Planning Application Ref: Y/4/19/RES

Location: Cinders Lane Nursery & works to R/O Cinders Lane, Yapton, BN18 0JJ

Description of works: Approval of reserved matters following outline consent Y/5/17/OUT for 51 No. dwellings. This application affects a Public Right of Way

Barrell Plan Ref: 18209-BT4

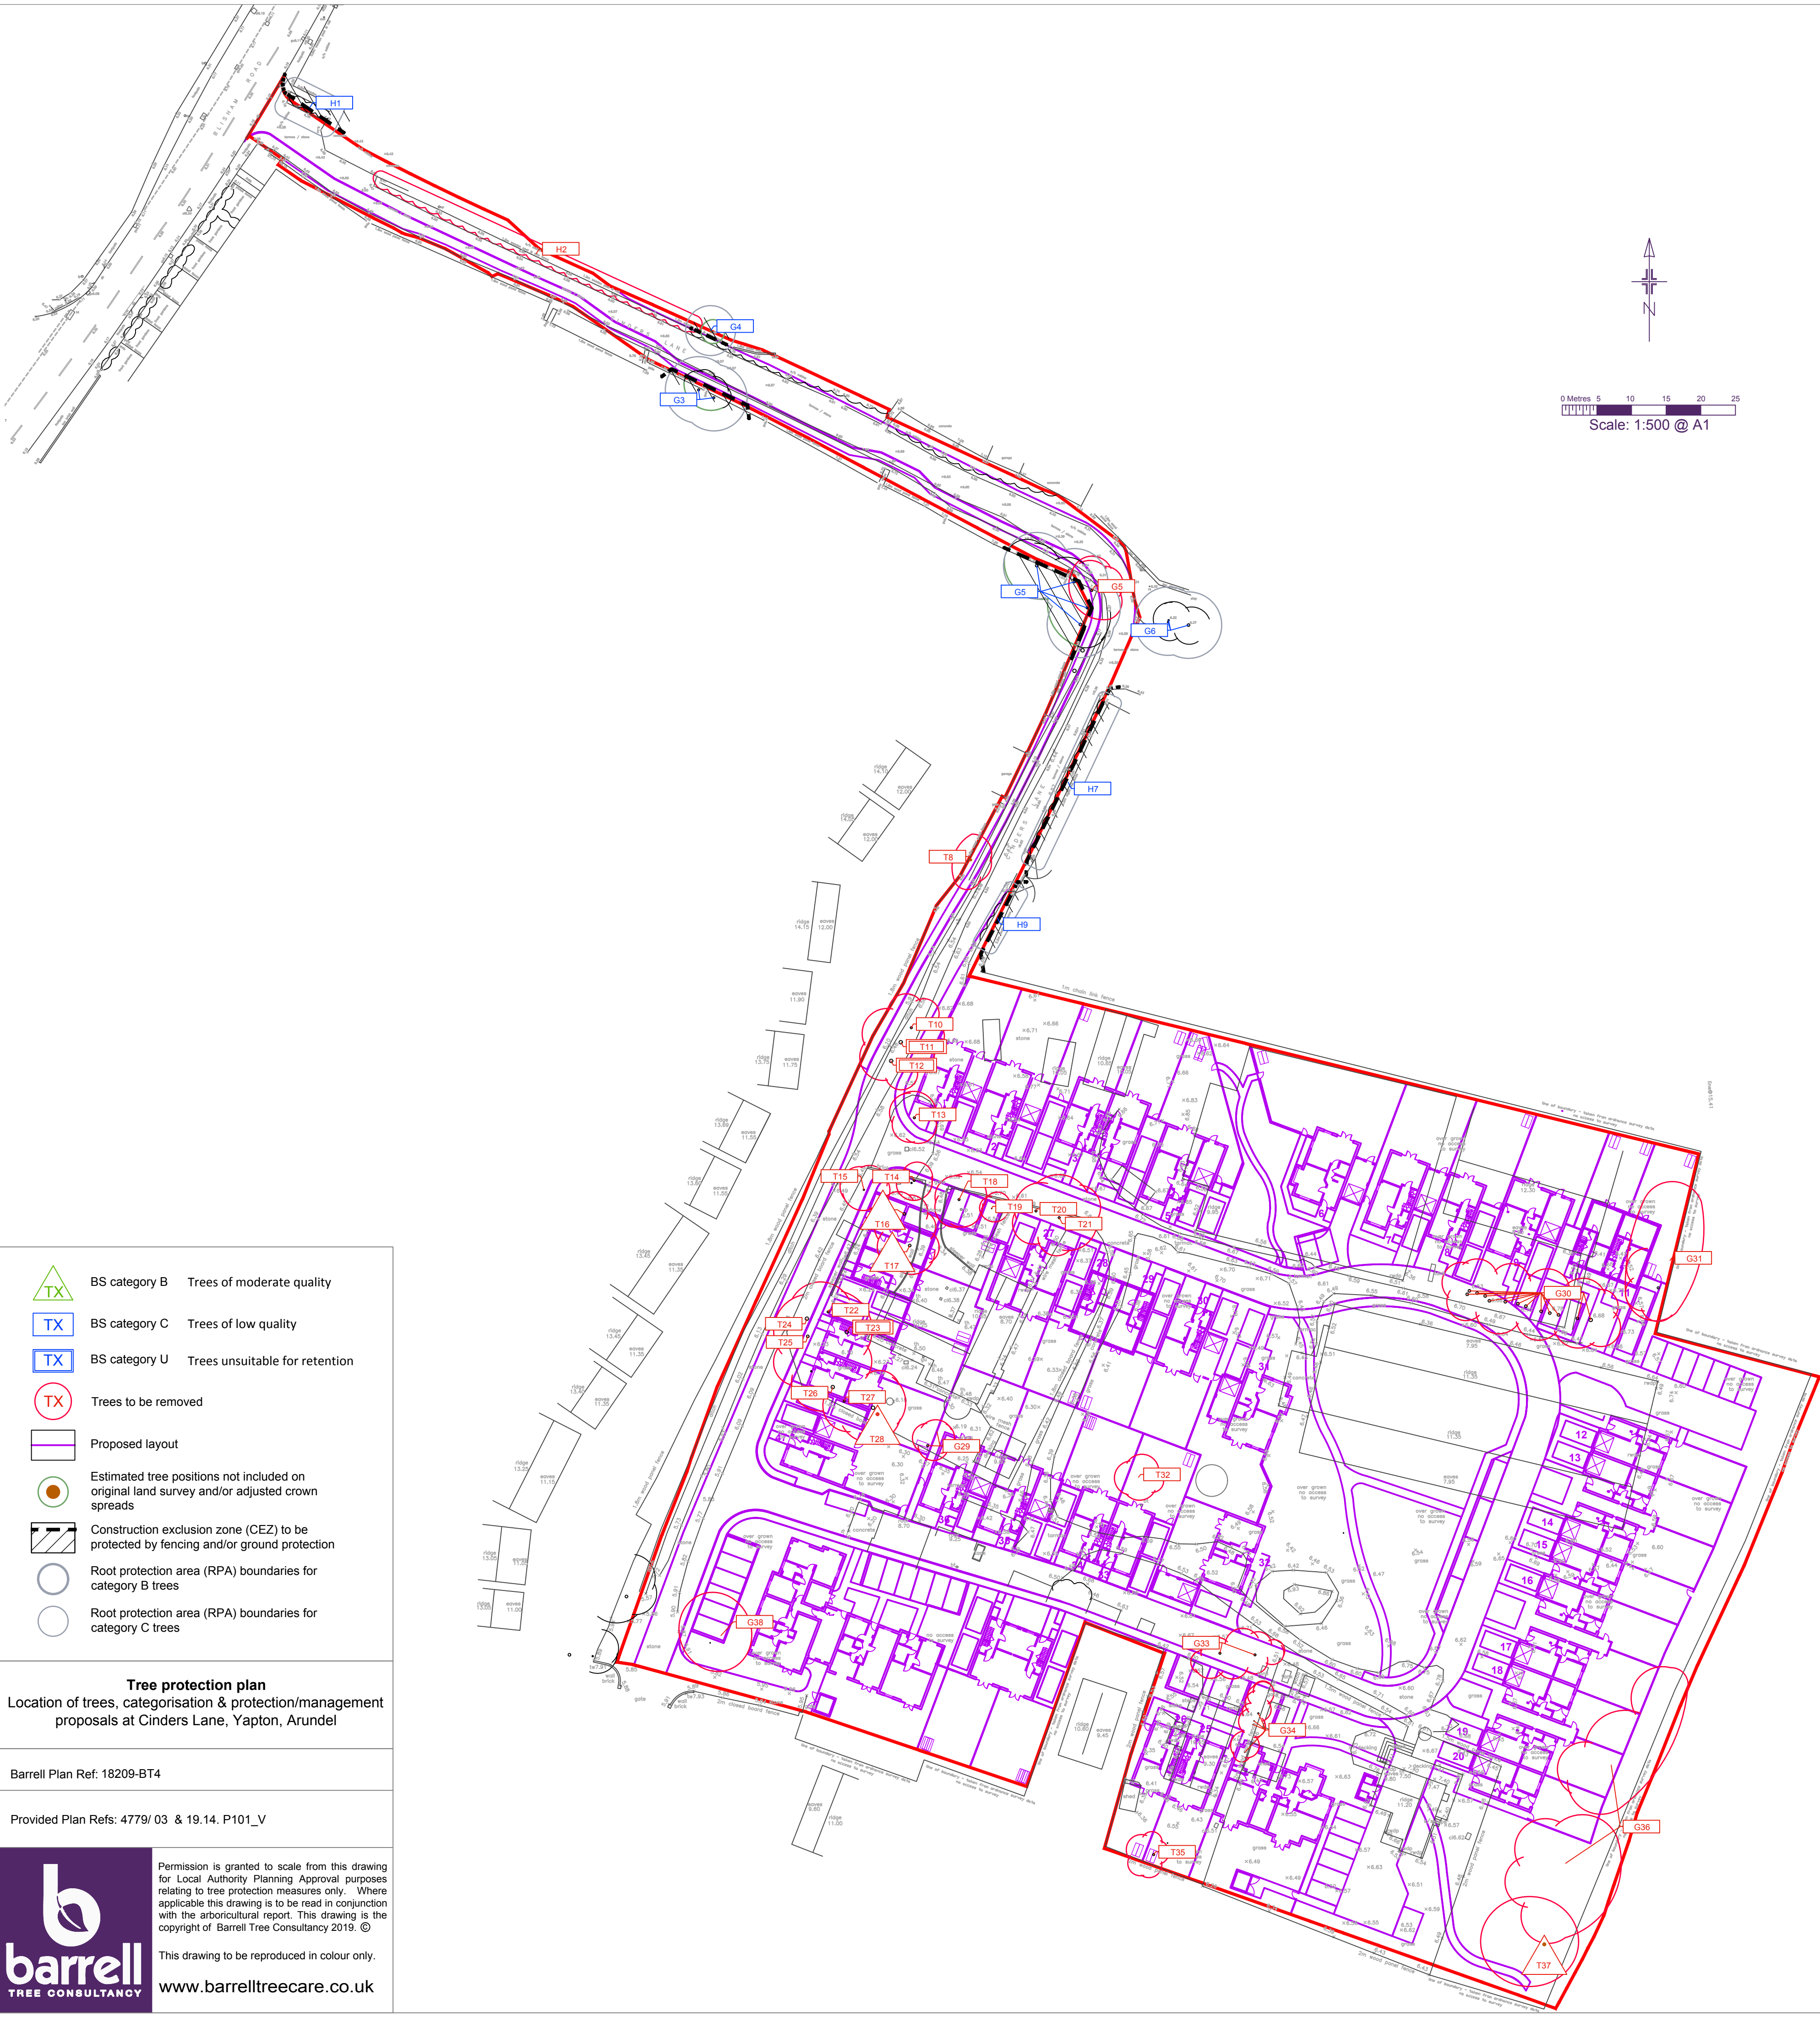
- All activity at the site is to be carried out in strict accordance with: - **Arboricultural Assessment & Method Statement, ref. 18209-AA4-CA, Barrell Tree Consultancy, 20th June 2019.**
- Before the site is occupied or any machinery is introduced to the site or demolition work or construction work or alterations to existing ground levels takes place a **PRE-COMMENCEMENT Site Meeting** is to take place between the Planning Authority's Tree Officer and the Arboricultural Expert representing the site owner(s) – at this meeting all protective fencing and ground protection measures will be inspected to verify they are 'Fit for Purpose' as required under British Standard 5837:2012 and have been erected and positioned exactly as shown on the **Tree Protection Plan, ref. 18209-BT4.**
